Submission on Culburra West Development Application: concerns and suggested improvements.

Please find below my comments on the Concept Plan Application.

References in brackets refer to pages /diagrams in the Environmental Assessment (EA).

View of 5-Storey Units

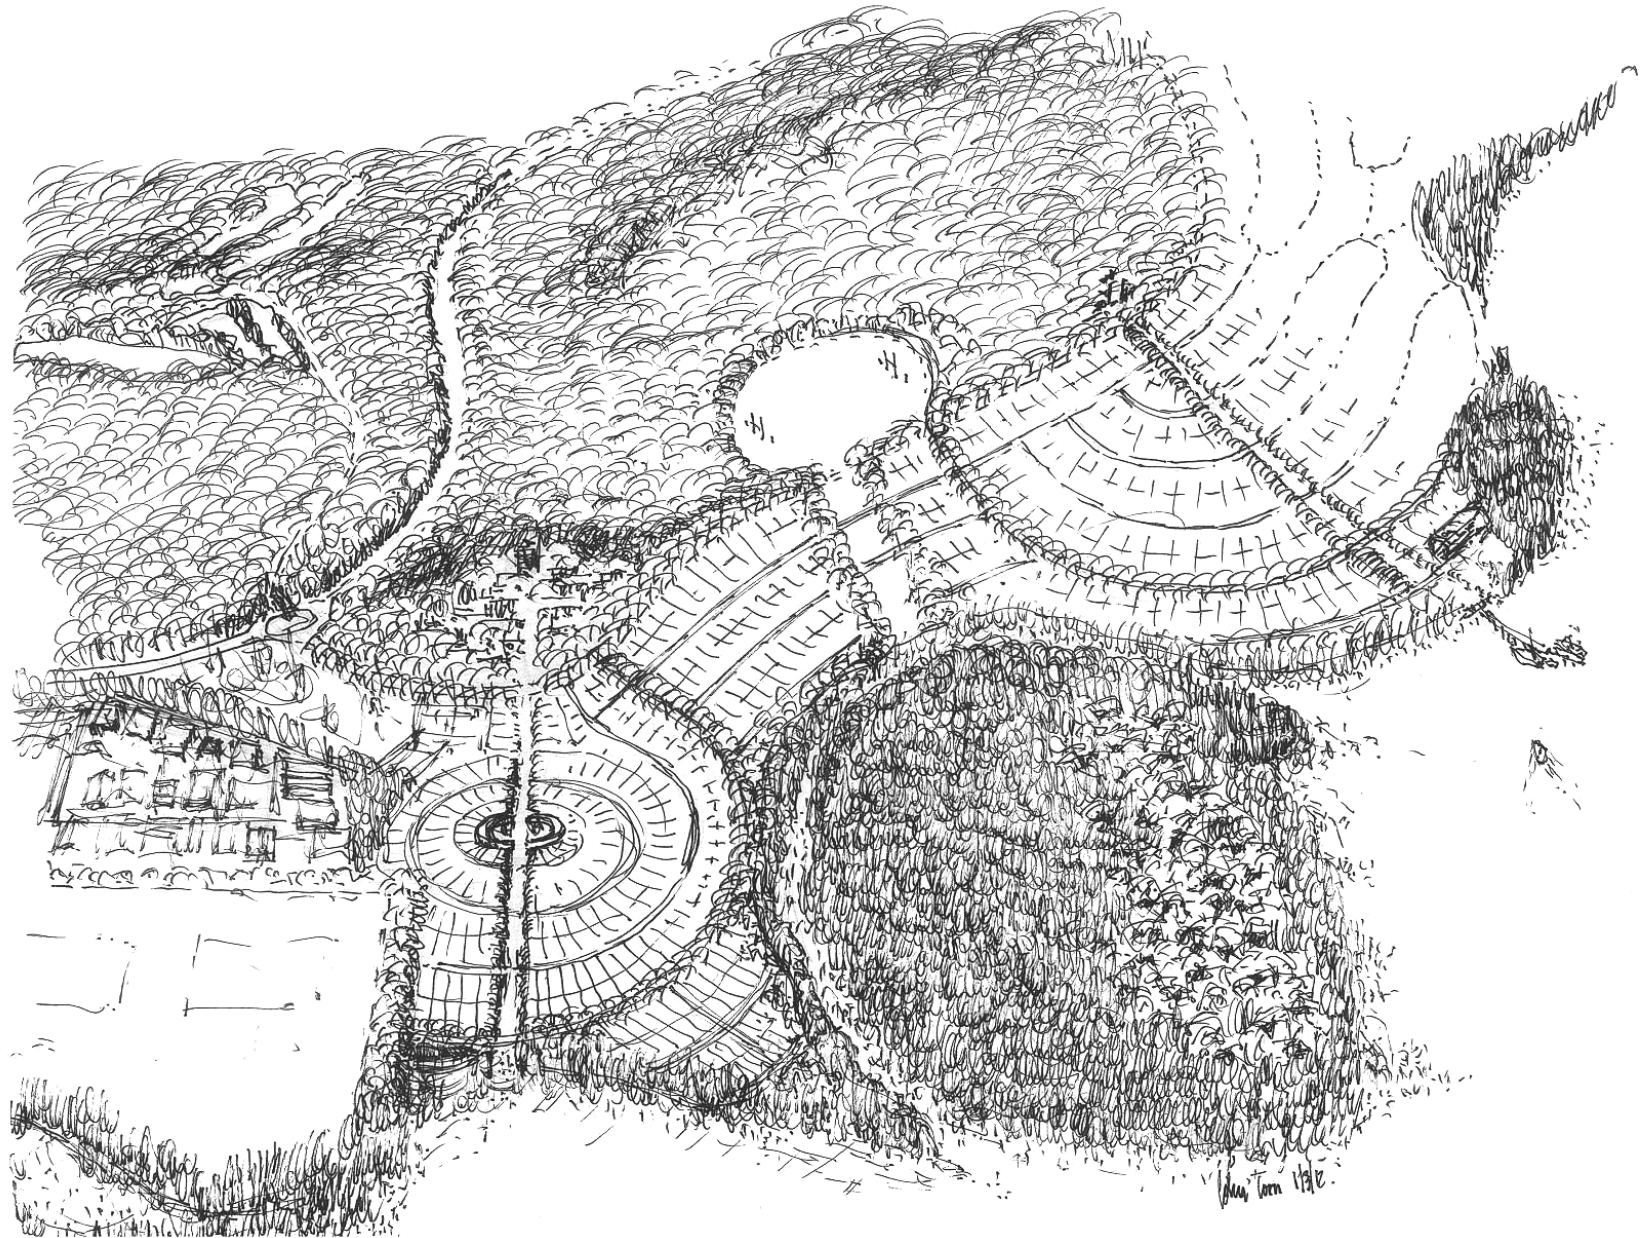
a) Stage 1 50 units, four stories.

This would be the “entrance statement” to Culburra and is totally out of character with the town (see illustration 5 in EA). The reference in the EA to four stories in the Coastal Design Guidelines is misleading – the Guidelines refer to medium density in town, not on the approach to town.

Despite the EA claiming that there will be “negligible impact” (135), it seems to contradict/ cover for this a number of times:

- “The proposal will change the local character around the Town Centre” (125). This is despite the EA acknowledging that the community “expressed a desire to retain what is termed the village atmosphere” (134)
- Illustration 5 states that the proposed pine tree planting “screens the four storey buildings behind”
- That the buildings would be given a “seaside appearance” (65)
- “Will only be seen when entering and exiting town” (135)

The proposed height is also excessively higher than Council’s DCP 71 controls. The EA acknowledges this (130)

It is also not in the spirit of the protecting the Lake catchment.

This element threatens the character of Culburra and should be deleted from the Concept Plan.

View of the Circus towards the "Outlook Tower"

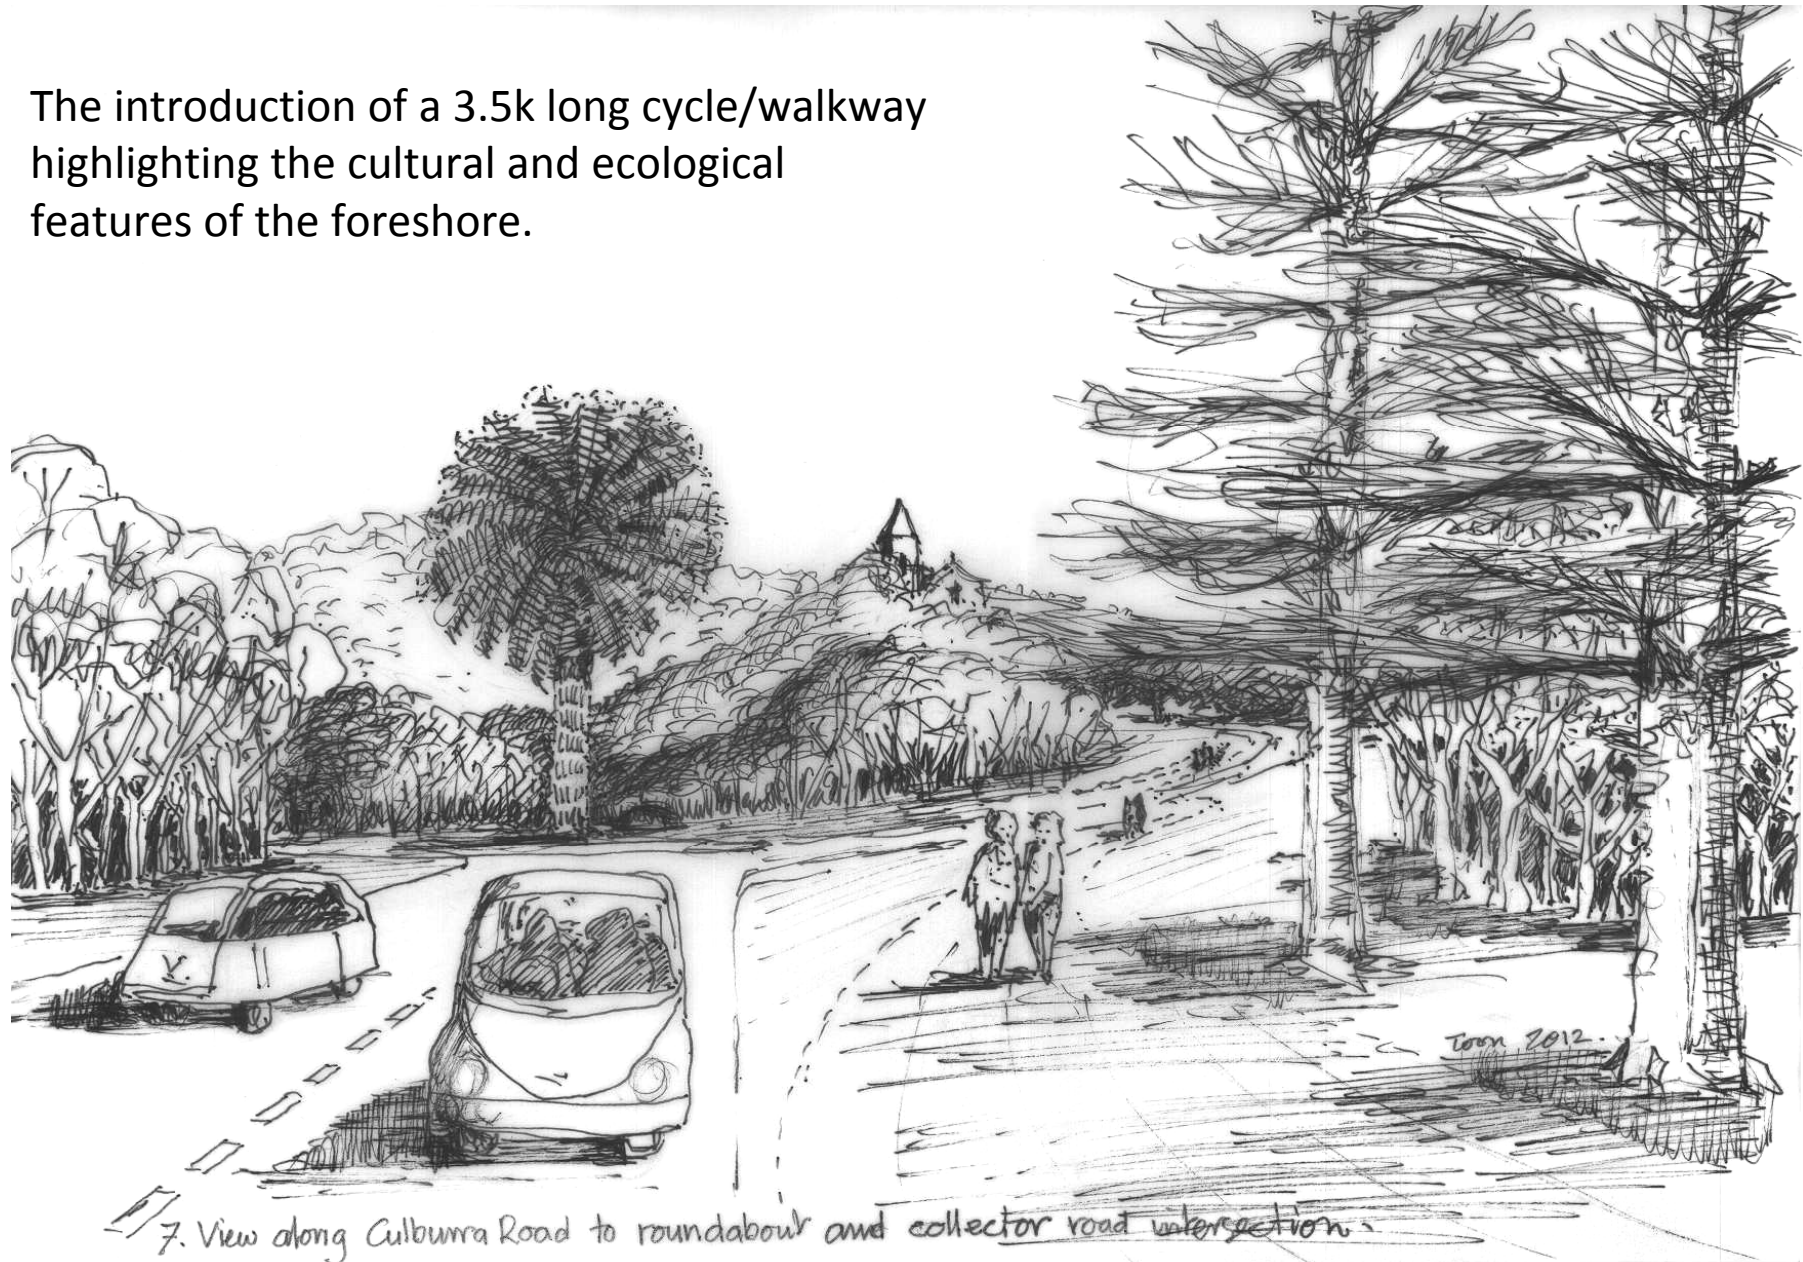
c) Stage 2, at the Circus

Illustration 7 gives the impression that the scale of this poorly sited centre will be greater than the existing Town Centre. Most misleading. It is poorly located in the half circle (shown as a full circle in many of the illustrations), proposing three storey buildings immediately adjacent to the industrial area and close to the Sewerage treatment works. Poor interface treatment. See 2 and 6.

Despite such concerns the EA refers to the half-circle as “the centrepiece of Stage 2”. It could be.

This element should be reconsidered by the proponent before any Concept Plan approval.
